A303 Sparkford to Ilchester Dualling Scheme TR010036

8.6 Draft Statement of Common Ground with Somerset Drainage Board Consortium

DRAFT STATEMENT OF COMMON GROUND

2.11 Outline Drainage Works Plans

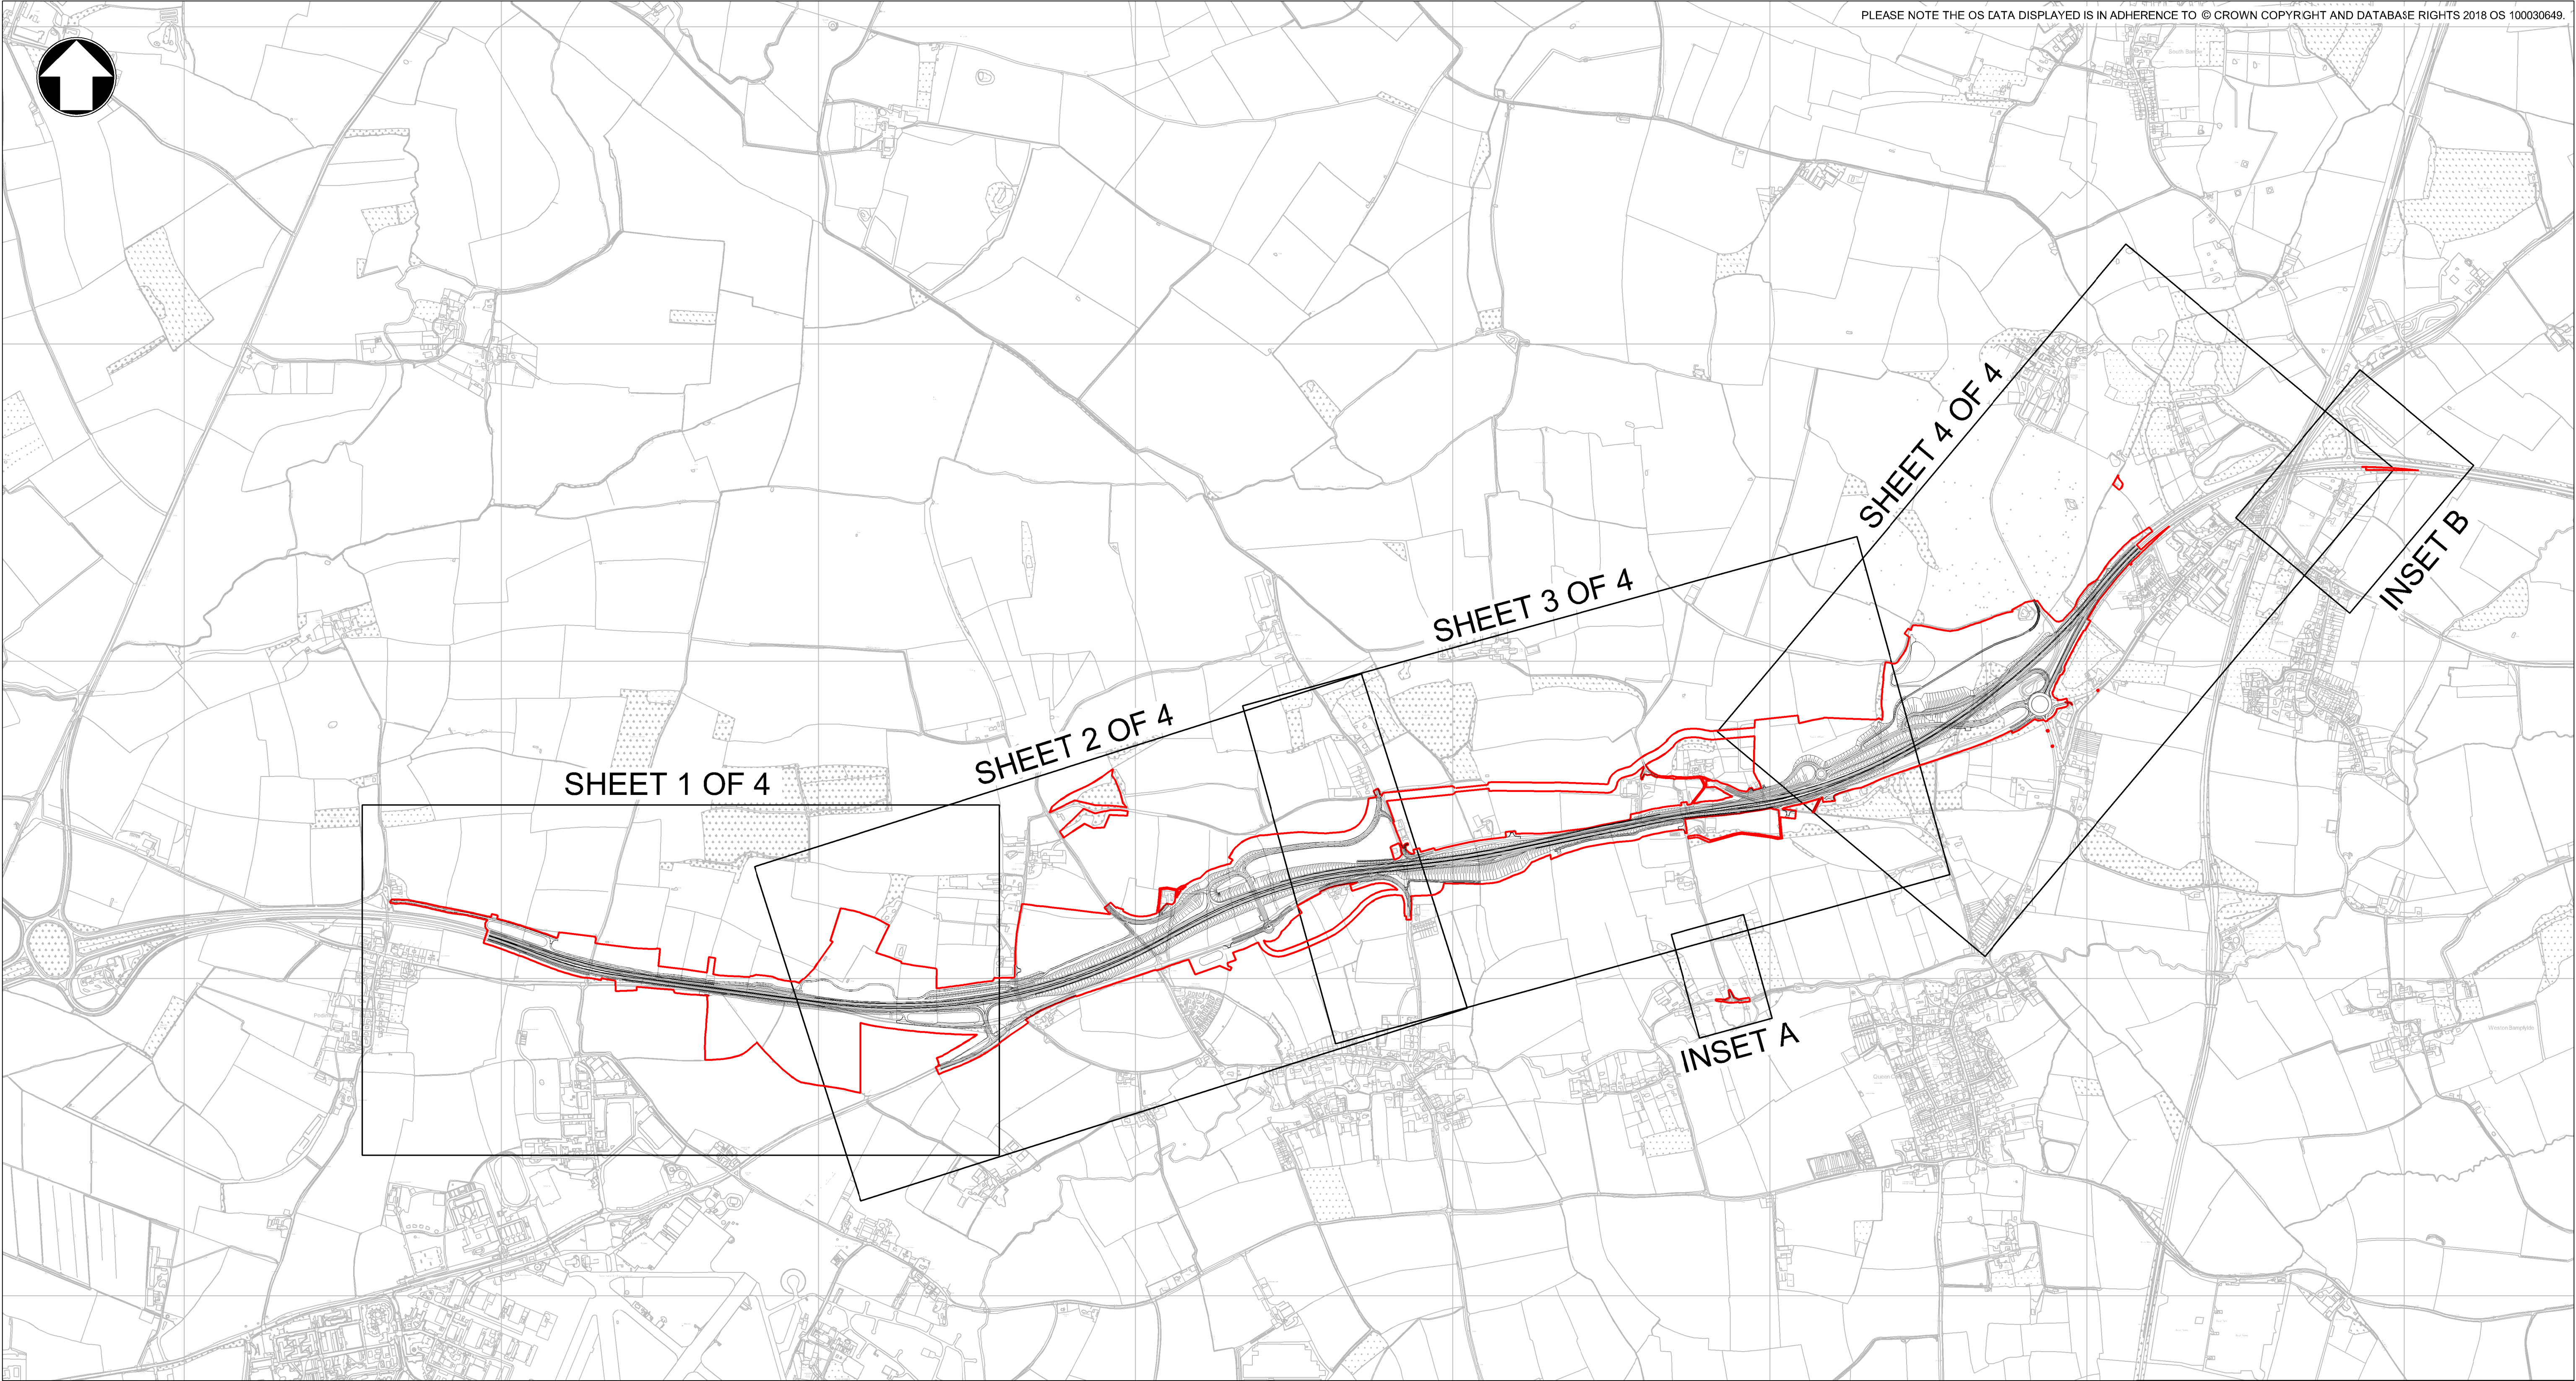
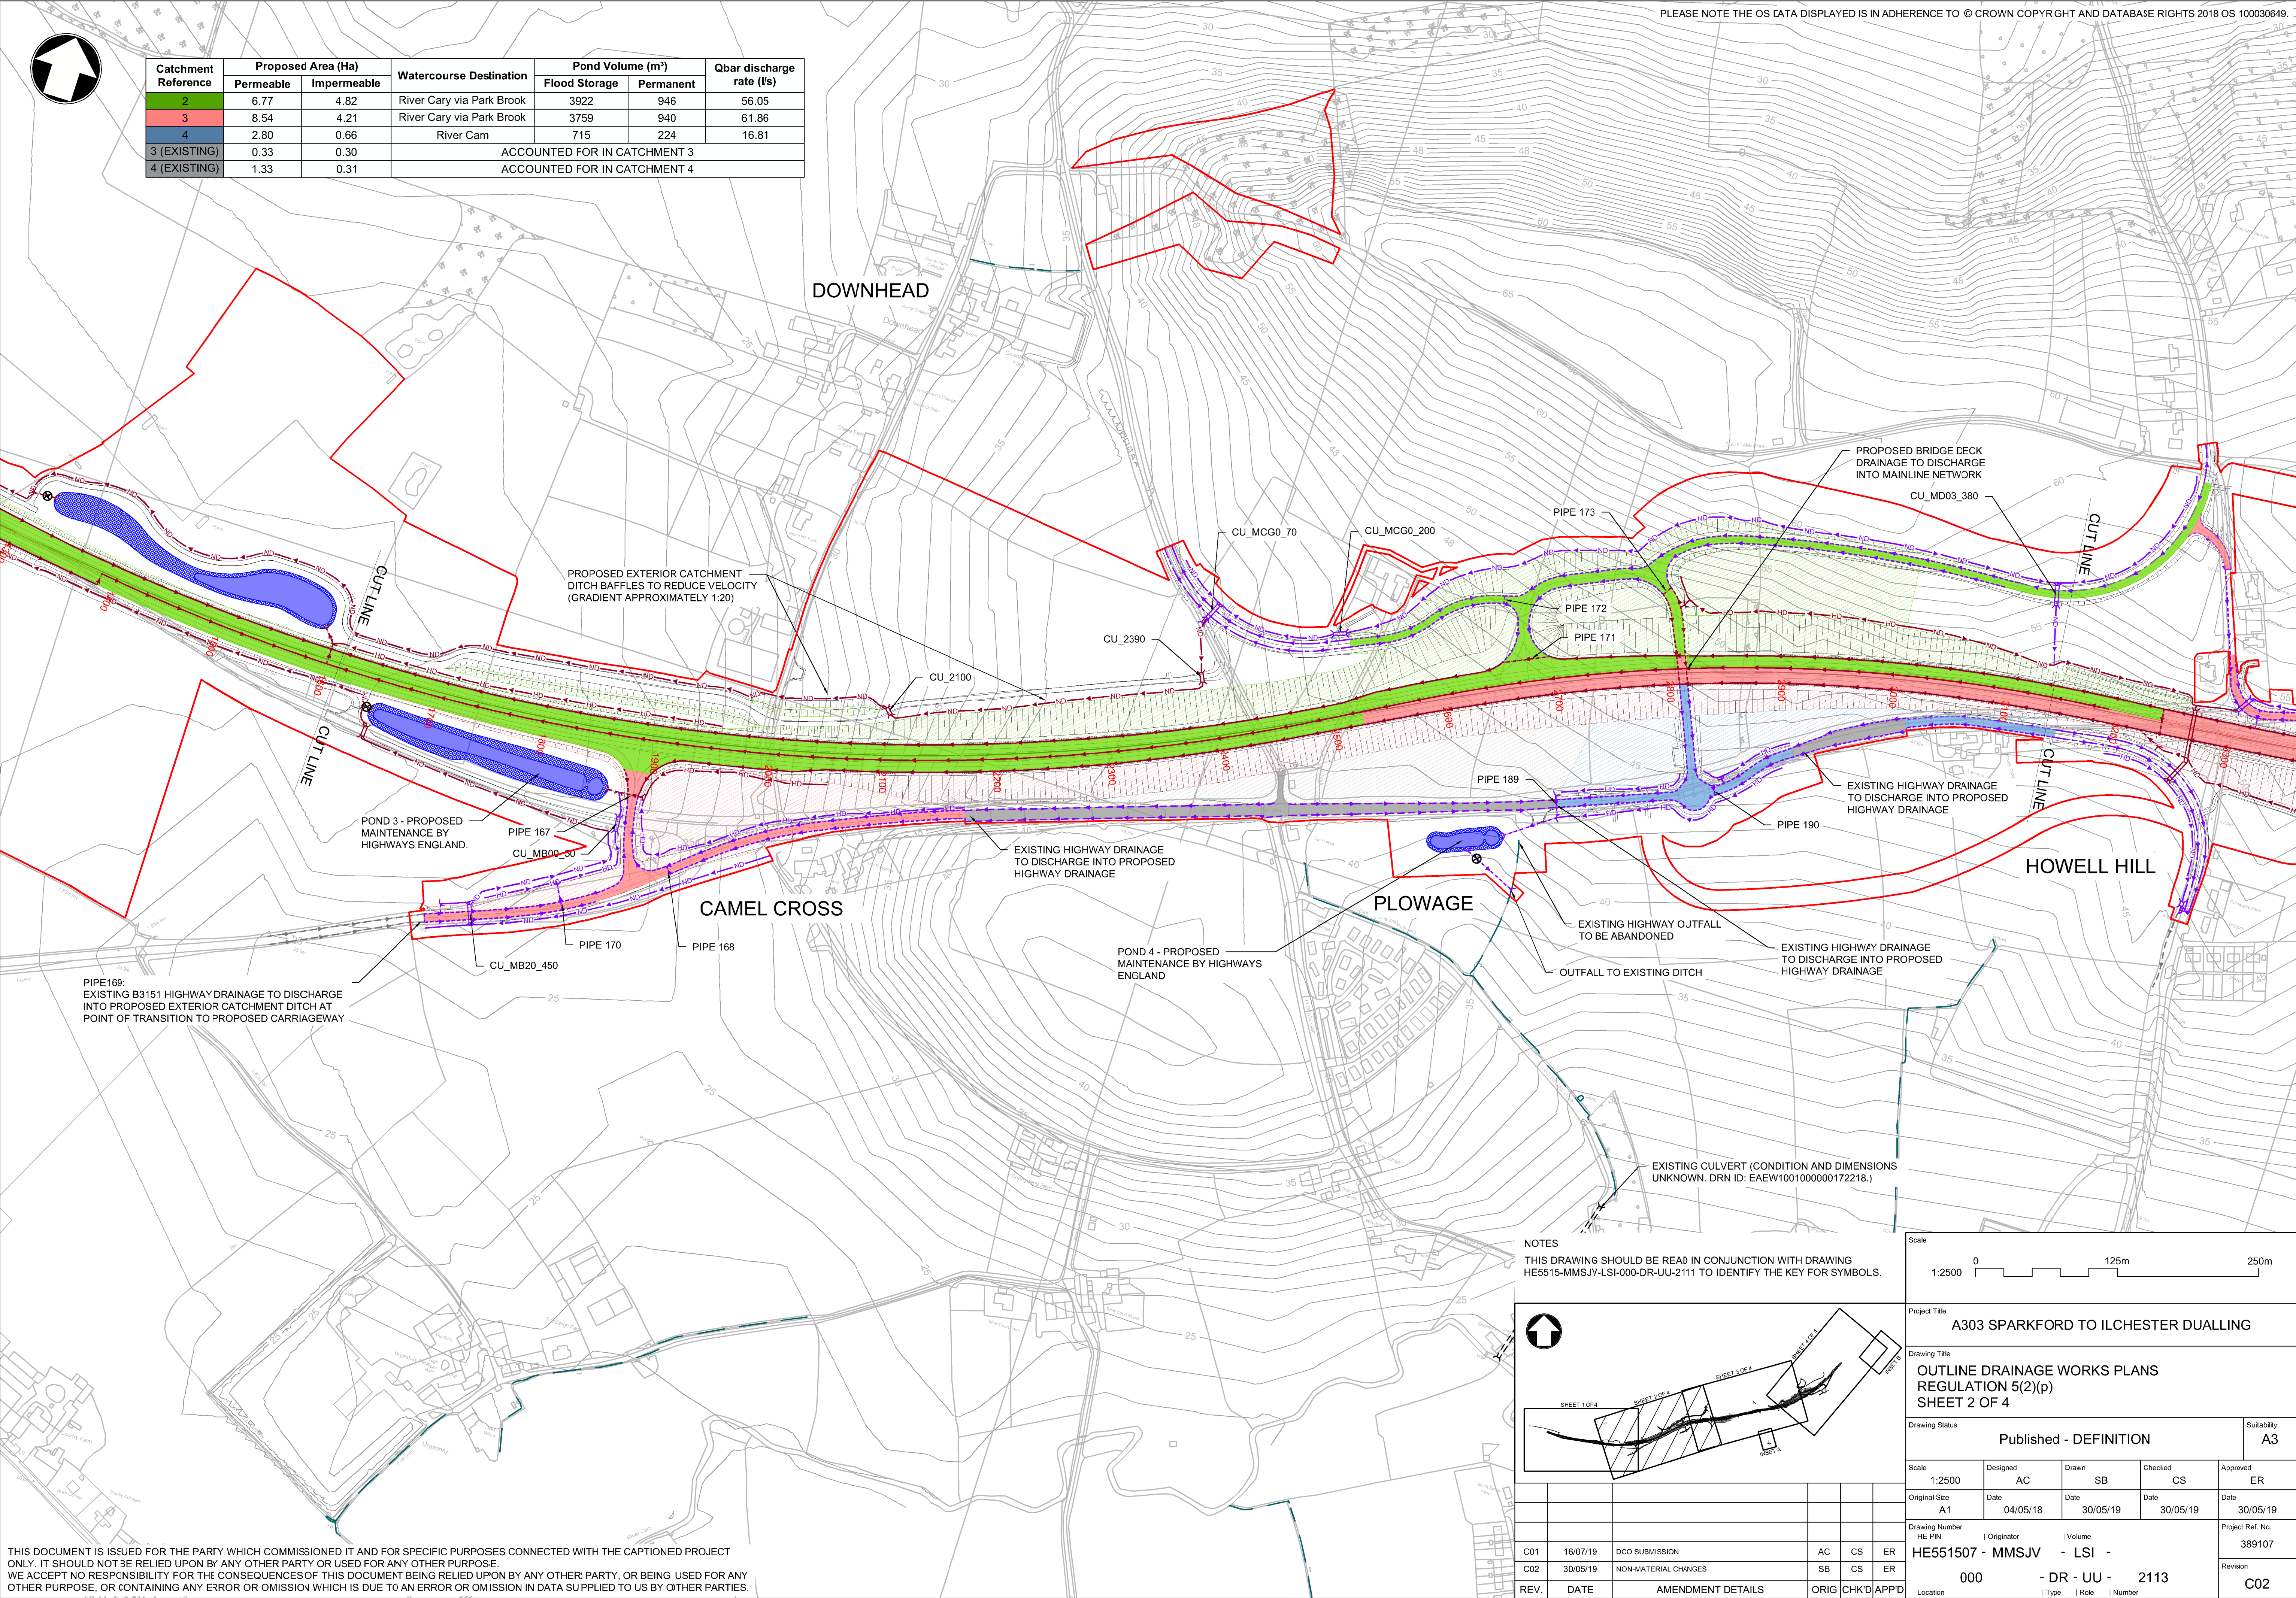
Topic	Stakeholder Comment	Highways England Response	Status
Water quantity	Confirmation is sought that the proposed design will control the overall volume, as well as the overall rate of runoff with sufficient attenuation provided.	Attenuation has been provided, with discharge limited to 1% annual exceedance probability (1 in 100-year event) plus 40% to account for the effects of climate change (Flood risk assessments: climate change allowances, Environment Agency), to no greater than the undeveloped rate of runoff, determined by the calculation of the mean annual peak rate of runoff for a greenfield site (Qbar). Preliminary design discharge rates and volumes shown in Outline Drainage Works Plans (APP-106).	AGREED
Water quality	Confirmation is sought that the proposed pond design provides effective water quality treatment with the use of a permanent water level, and that this volume is sufficient in size. It is recommended that the SuDS Manual (C753) is referred to in the calculation of these permanent volumes, as well as the detailed design of the forebays and vegetation that will be essential for water treatment.	A permanent water level has been provided for each of the proposed ponds. The volume of treatment has been provided in accordance with the SuDS Manual (C753) - '10-15 millimetres of rainfall depth falling over the contributing catchment'. Accepted. Appropriate planting has been considered as part of the landscaping assessment and design. Attenuation feature discharge rates and volumes shown in Outline Drainage Works Plans (APP-106).	AGREED

Topic	Stakeholder Comment	Highways England Response	Status
		As in accordance with Outline Drainage Works Plans (APP-106).	
Maintenance and access	<p>There is concern that there is not adequate space provided for adequate and effective maintenance of the ponds and ditches.</p> <p>It is recommended that maintenance tracks are provided, ensuring connectivity to the ponds and ditches.</p> <p>To undertake a full de-silt of the ponds a maintenance strip greater than 4m is required. Further information needs to be supplied on this at the detailed design stage.</p>	<p>A grassed 4 metre maintenance strip has been provided around each pond and along each ditch. Additional access tracks have been provided to provide access to the ponds.</p> <p>As in accordance with Outline Drainage Works Plans (APP-106).</p>	UNDER DISCUSSION
	<p>There is concern that the maintenance tracks do not provide access to the control structures, which would need to be maintained and accessed in the event of a large pollution incident.</p>	<p>Accepted.</p> <p>The ponds and maintenance tracks have been redesigned to provide access to these structures.</p> <p>Access shown in Outline Drainage Works Plans (APP-106).</p>
